From: Stuart Corbey
Sent: 01 May 2019 14:39
To: Planning.Responses
Subject: FW: 22 North Way, Felpham - Replacement of bungalow with a chalet bungalow (FP/249/18/PL)

From: Richard Wickens [REDACTED]
Sent: 18 March 2019 12:10
To: Stuart Corbey
Cc: All Councillors
Subject: RE: 22 North Way, Felpham - Replacement of bungalow with a chalet bungalow (FP/249/18/PL)

SITE BLOCK PLAN 1:500

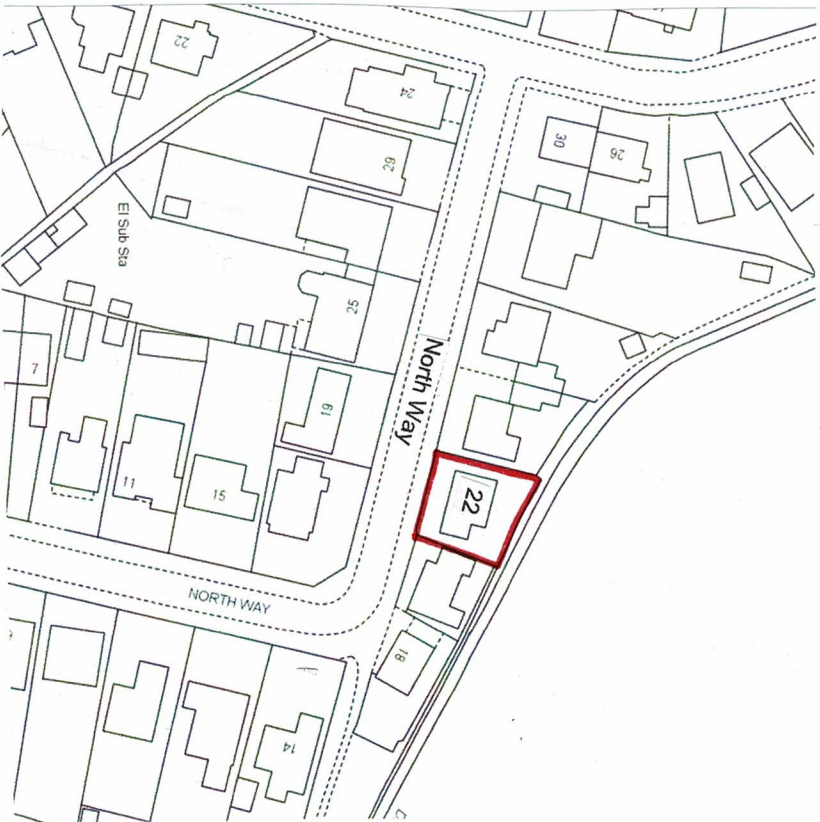
- There is no identification of car parking on the block plan or submission made under FP/259/17/HH. Therefore our approval for this previous application was sound.

- The new application FP/249/18/PL includes a block plan showing car parking which is why a comment was made on this application with regard to this issue.

- The two car parking bays proposed are 2.15m wide by 6.45m long (a standard UK car parking space is 2.4m by 4.8m). In this respect the Council feels that the space to park the cars in parallel format as indicated on the plans could not be achieved.

DRAWING
PROPOSED PLANS
DRAWING No
236/04A
REVISION
SCALE 1:100
DATE SEPT 2017
DRAWN LA
CHECKED

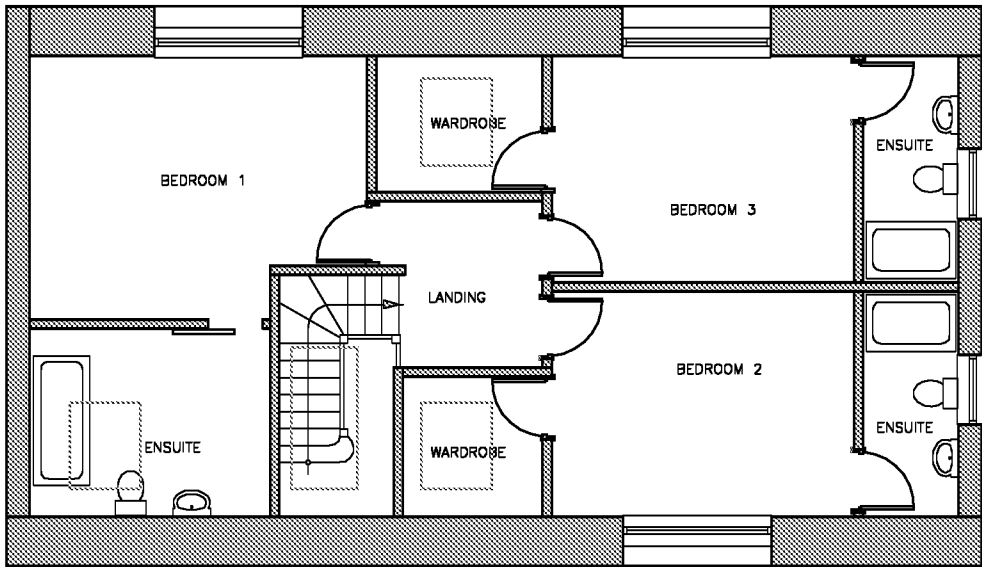
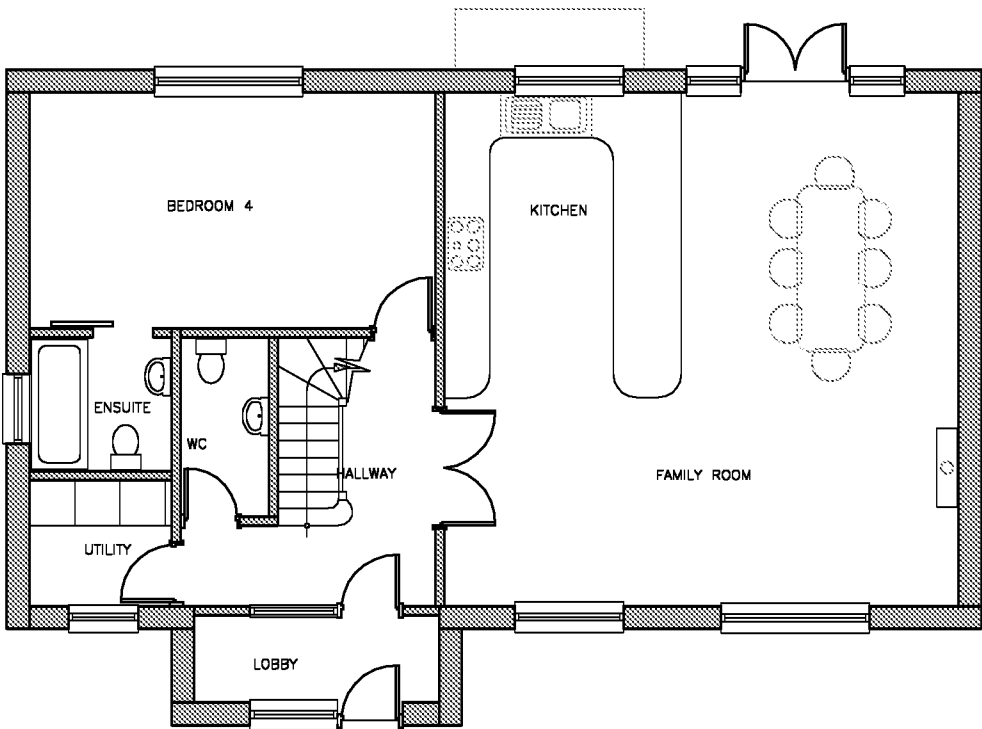
- There is a difference in both the ground and first floor lay outs/plans which further indicates that this is not the same as the approved designs previously.
